## **STARLITE ESTATES PERFORMANCE BASED CLUSTER PLAT**

## Memorandum

**Re:** Starlite Plat pre development meeting

STARLITE ESTATES

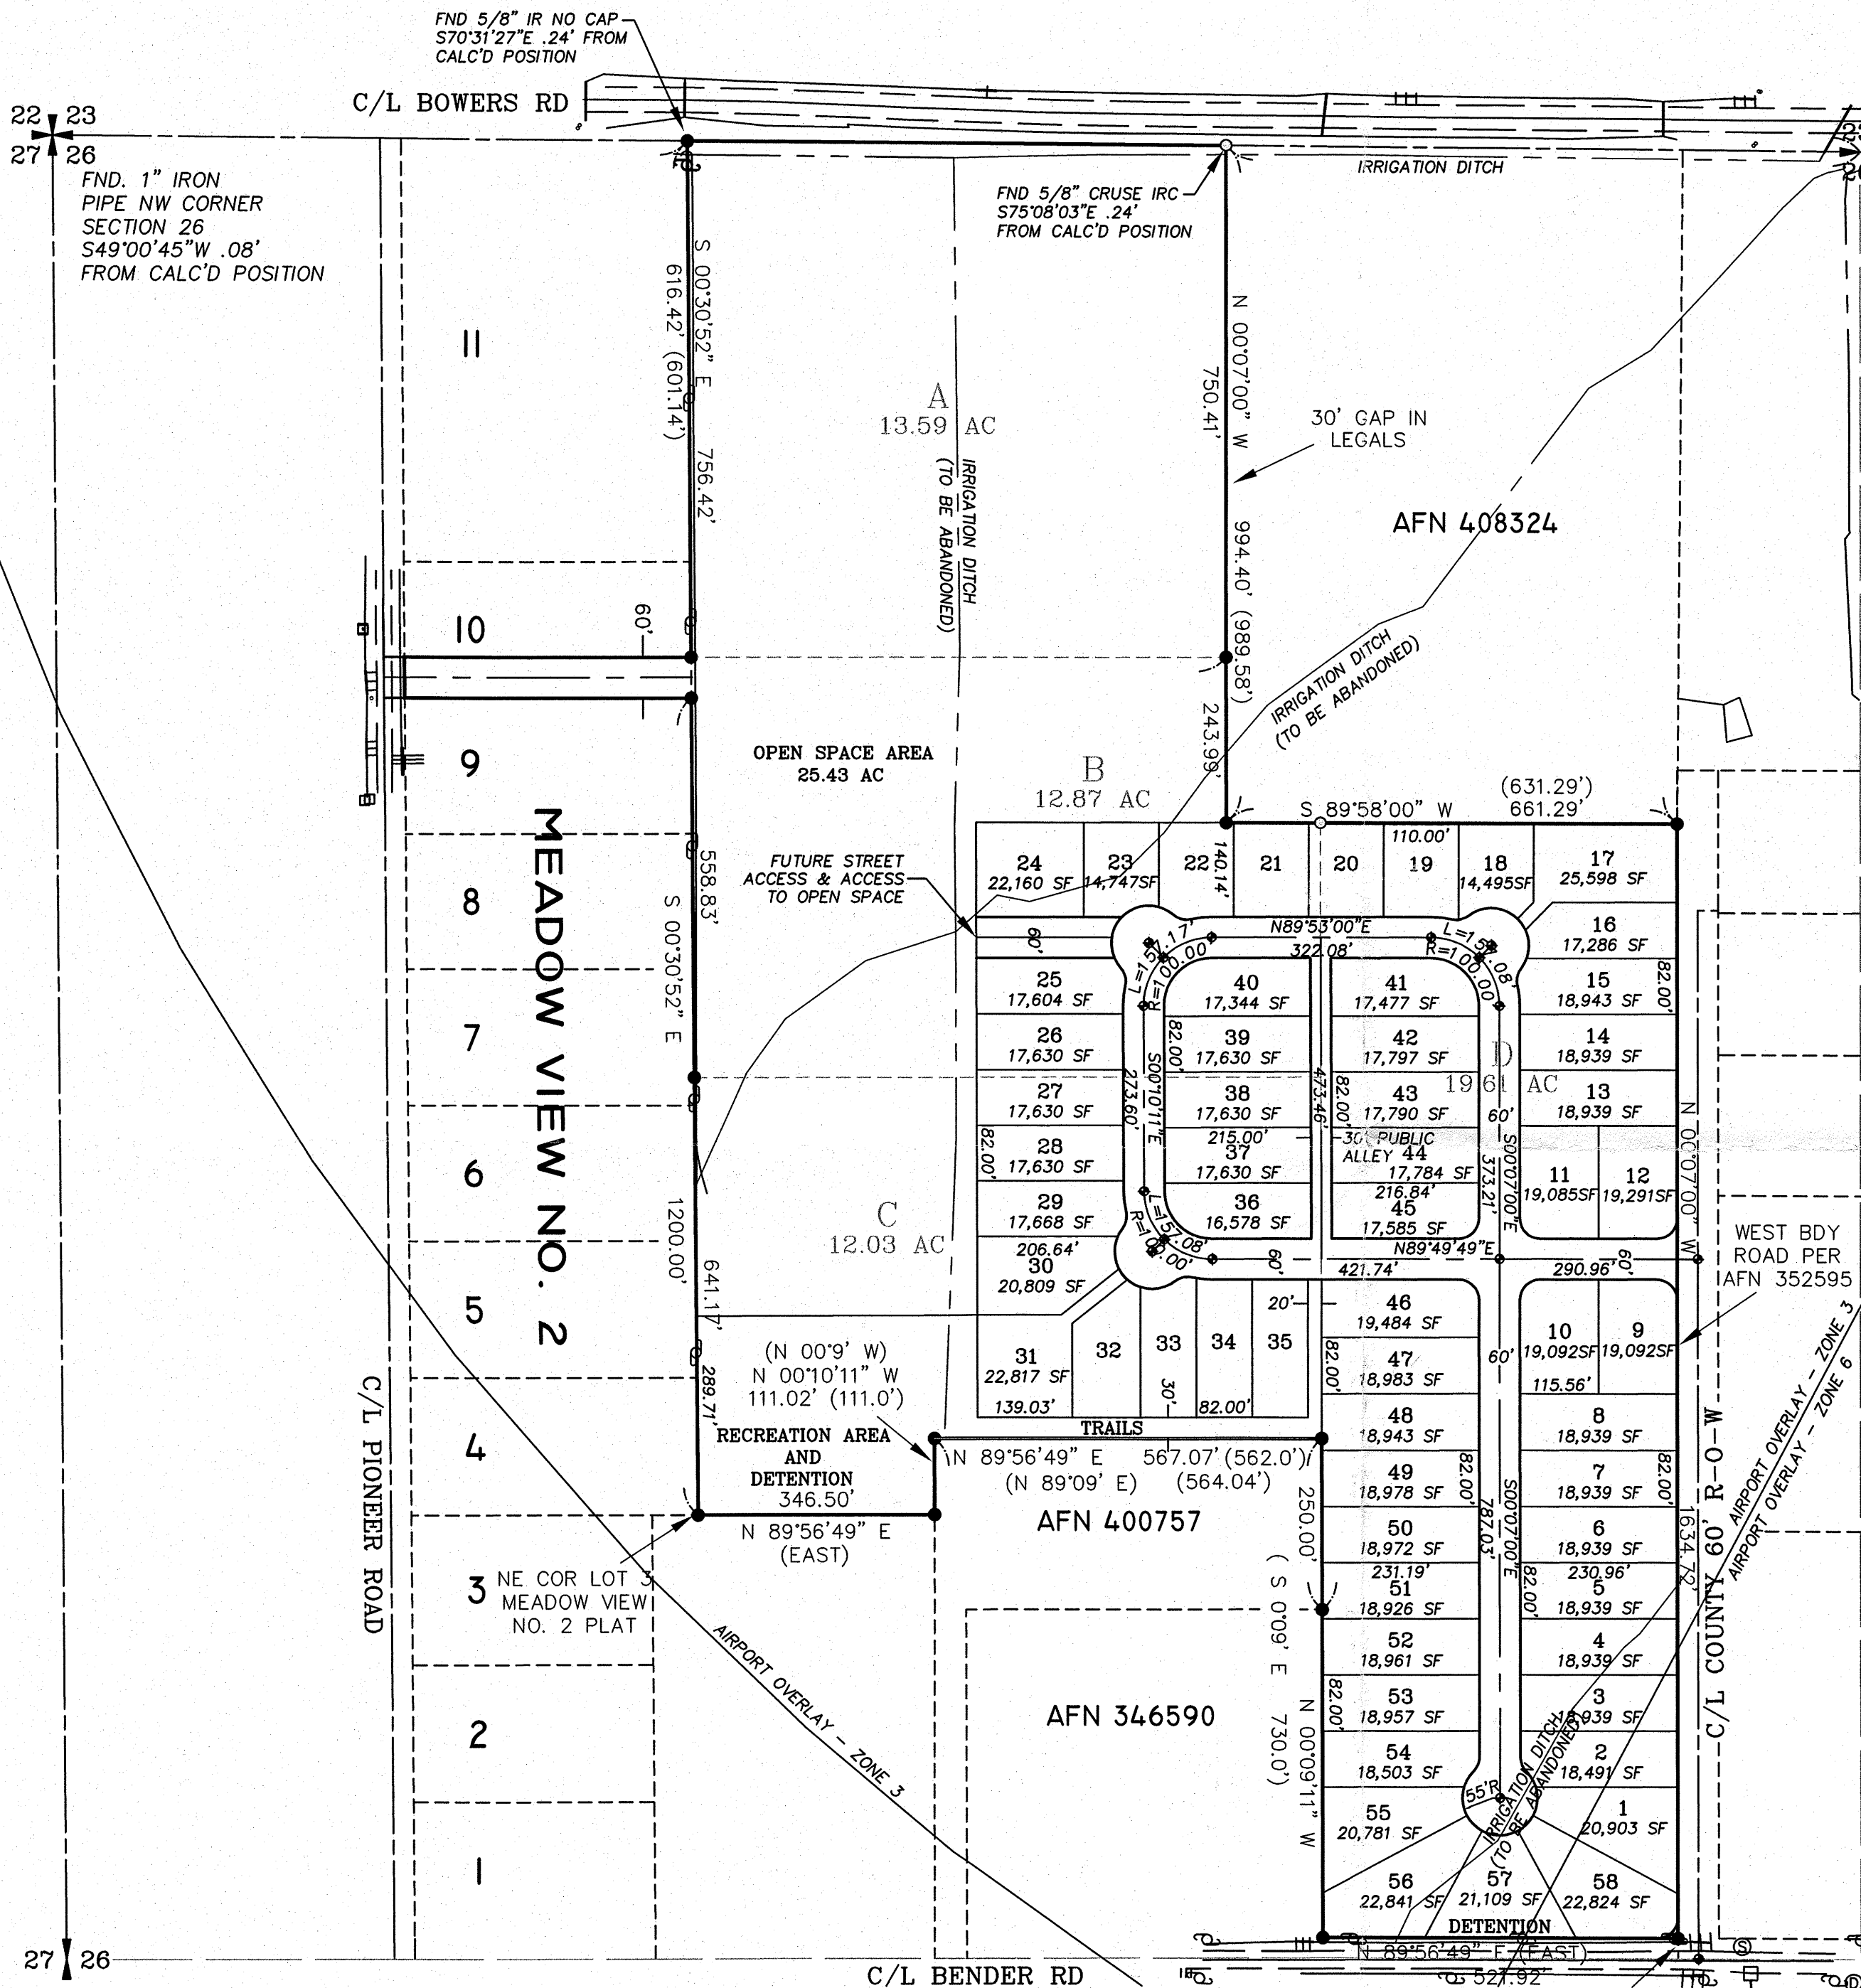
The proposed un-named north/south street does not line up with the proposed Columbia St. in the Stoney Creek Plat. Street alignments shall be per the Development Standards.

As discussed in the pre development meeting, Public Works will require the conversion of the proposed internal street's long radius corners into intersections, with roadways extending east / west, and north / south, according to the intersection.

Proposed roadway names shall comply with the City of Ellensburg road name ordinance. The preliminary drawing does not show a proposed street name.
